Section 96A of the Town & Country Planning Act 1990 (as amended)
Town and Country Planning (Development Management Procedure) (England) Order 2015 (as amended) - Article 10

Application for a Non-Material amendment to previously approved planning application R/19/14 to omit small gable roofs over south facing bay windows.
34 Cudlow Avenue, Rustington, ,

Accordingly drawing number 0149/102 revB has become the approved plan for planning permission R/19/14.

Proposed South Elevation (front)
Scale 1:100 @ A1

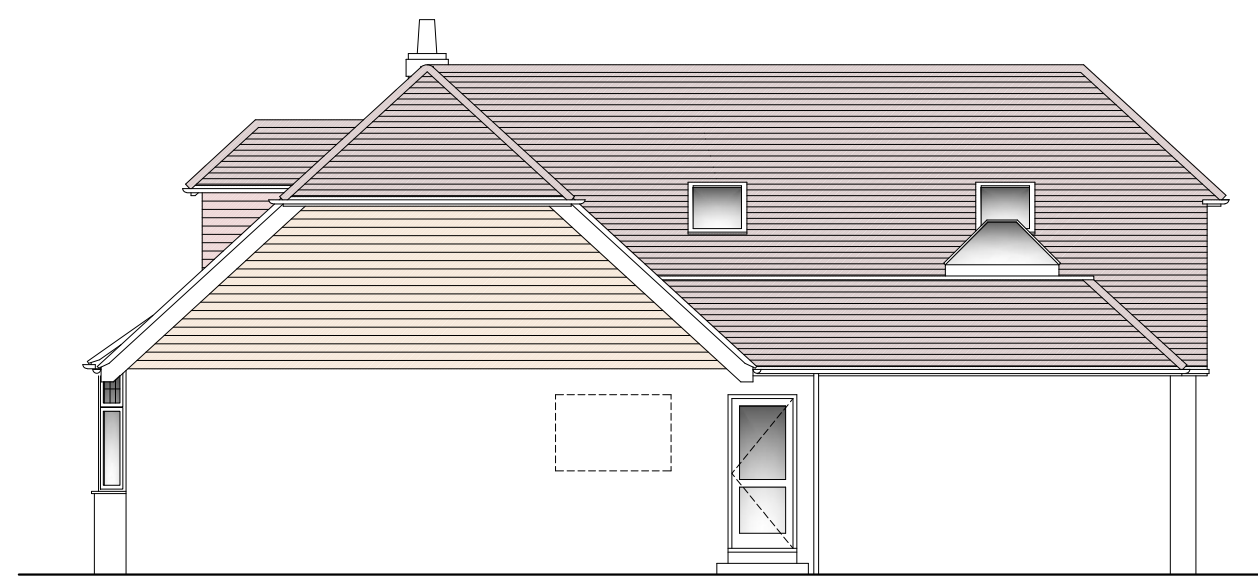
I refer to your recent application for a Non Material Amendment. From the information submitted I am able to take the alterations proposed namely the omission of the approved gable roofs over the south facing bay windows as a Non Material Amendment to R/19/14/.
